Recommendation Report for Planning Permission for Works or Extension to a Dwelling

REF NO: M/9/19/HH

LOCATION: Fidra
Yapton Road
Middleton-On-Sea
PO22 6DX

PROPOSAL: Two storey rear extension, porch to front and conversion of roof space with two front dormers

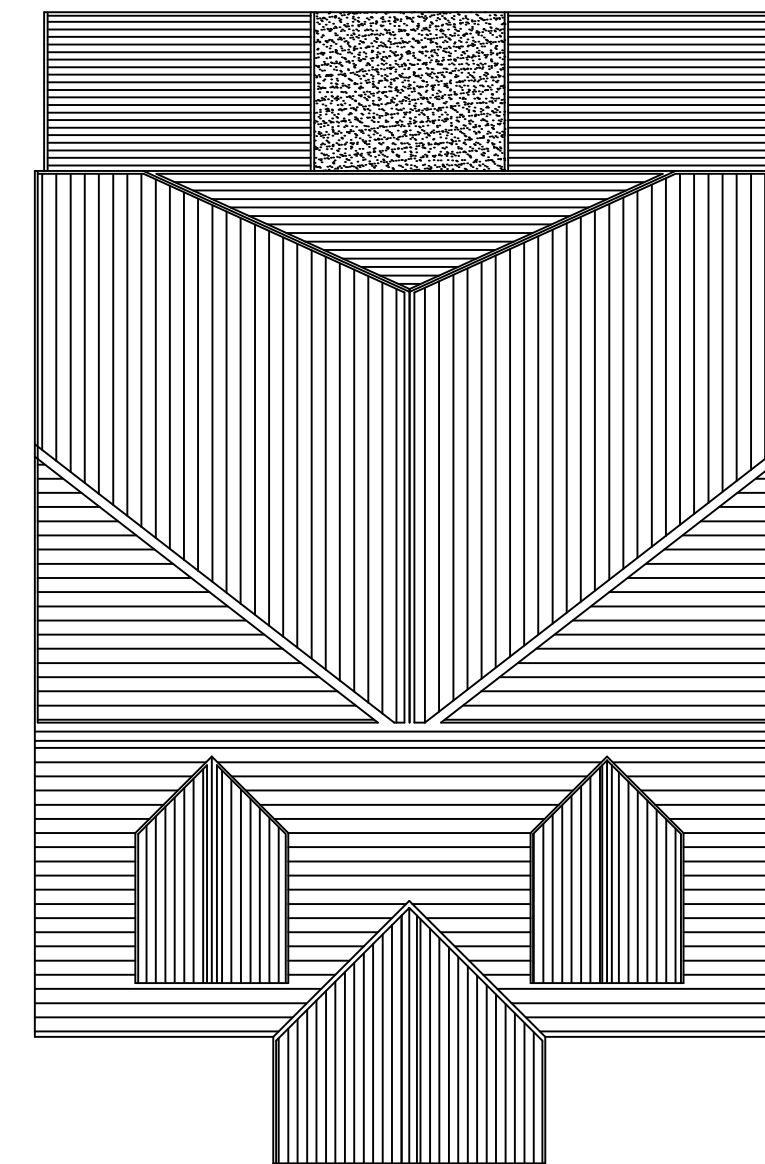
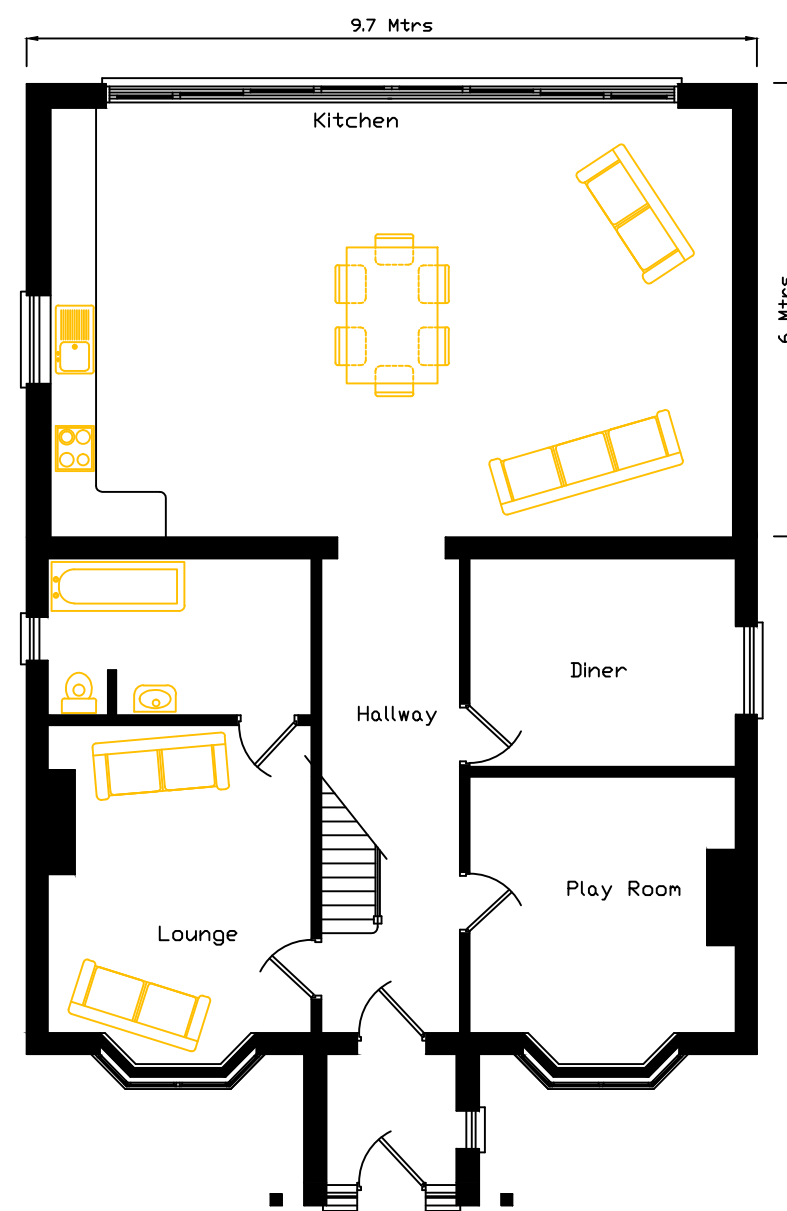
The proposed development is not considered to have any significantly detrimental overshadowing or overbearing impact upon occupiers of nearby dwellings. The proposed development is sited a distance of 1.5m from the neighbour to the North, and extends 4m to the East at first floor level, with a rear barn-hipped roof. These factors are considered to allow to the proposed development to have no significantly harmful unneighbourly appearance within the area, or to occupiers of neighbouring dwellings. Whilst it is noted that the proposed development features windows, the majority of these windows are not considered to result in views that result in any significant loss of privacy to occupiers of neighbouring dwellings. However, as a result of the layout of the property to the South, there is potential for direct overlooking from the window on this aspect into the neighbouring dwelling, and therefore it will be conditioned to be obscure glazed and non-opening below 1.7m. Therefore, the proposed development is considered to be in accordance with D DM1(3) and D DM4(c) of the Arun District Council Local Plan.

Rev 'A'	26-04-2019	First Floor reduced to 4 Mtrs
 extending homes Tel:- 01243 555208 enquiries@extendinghomes.co.uk		
TITLE:- Rear Extension @ 'Fidra' Yapton Road Middleton West Sussex PO22 6DX		
DATE:-	3rd March 2019	
SCALE:-	Elevations 1-100 on A2	
DRAWN:-	P.Robinson	
DWG. No. 1904031/PL/1A

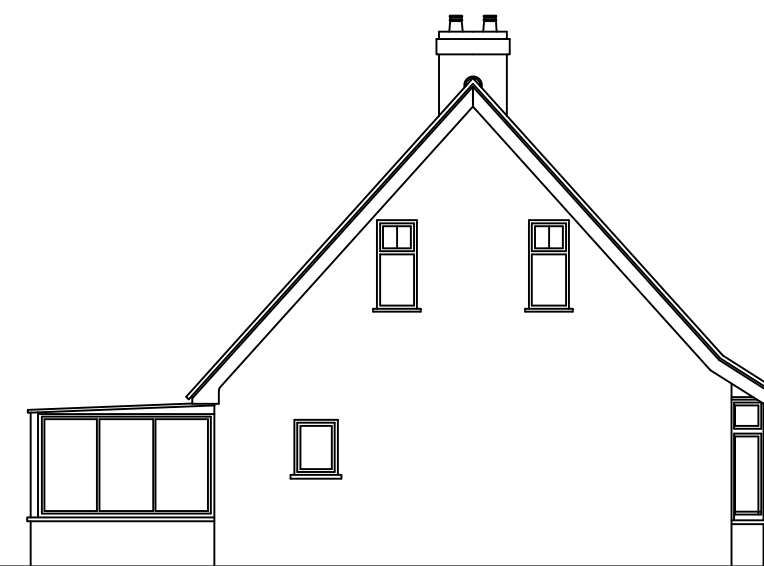
The proposed front dormers are visible within the street scene, however, they are considered to be an improvement to the appearance of host dwelling. They are considered to be sympathetic in design and well integrated with the host dwelling. Their maximum height is 0.15m lower than the maximum ridge height of the host dwelling, and they are sited more than 1m from the Northern and Southern ends of the

roof . Therefore, the proposed front dormers are considered to be in accordance with D DM1(2), D DM4(a) and (b) of the Arun Local Plan.

Rev 'A'	26-04-2019	First Floor reduced to 4 Mtrs
 extending homes Tel:- 01243 555208 enquiries@extendinghomes.co.uk		
TITLE:- Rear Extension @ 'Fidra' Yapton Road Middleton West Sussex PO22 6DX		
DATE:-	3rd March 2019	
SCALE:-	Elevations 1-100 on A2	
DRAWN:-	P.Robinson	
DWG. No. 1904031/PL/2A

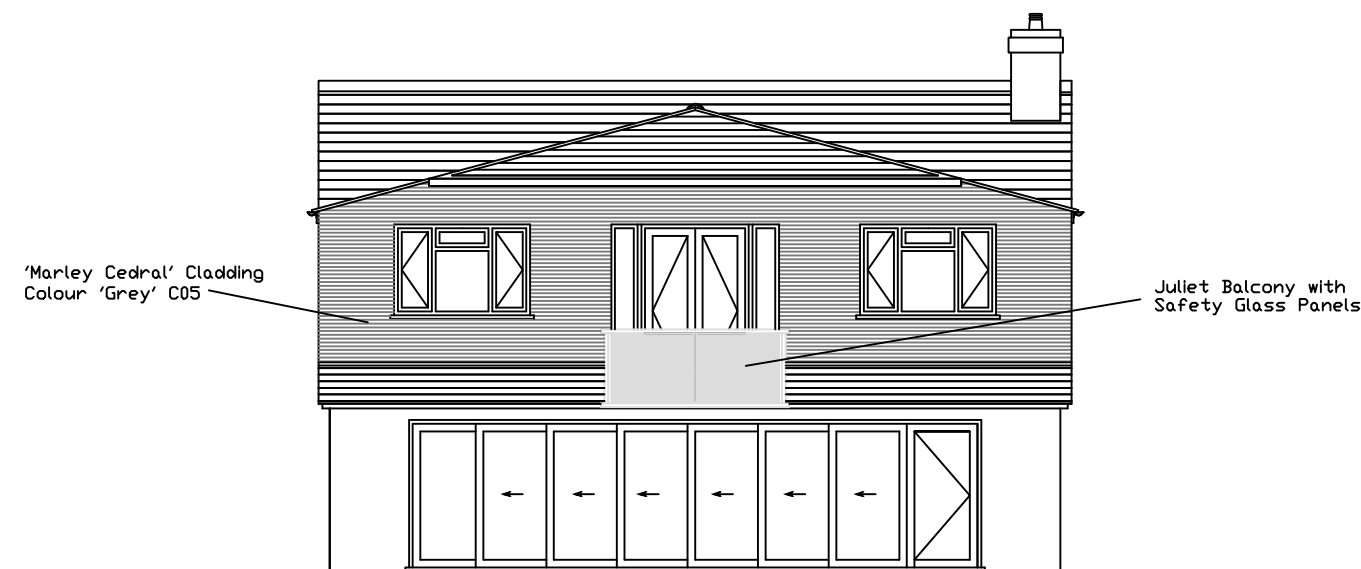
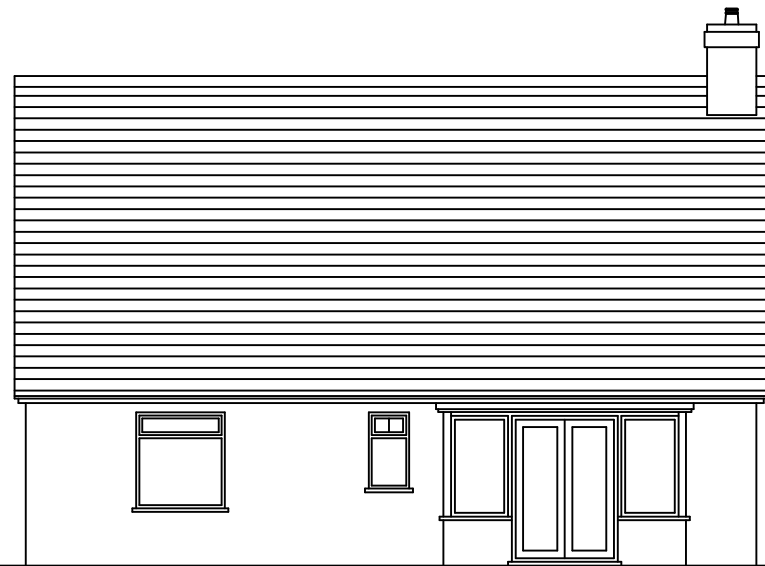
- 4 The windows on the Southern elevation of the building shall at all times be glazed with obscured glass and fixed to be permanently non-opening, below 1.7m, in perpetuity.
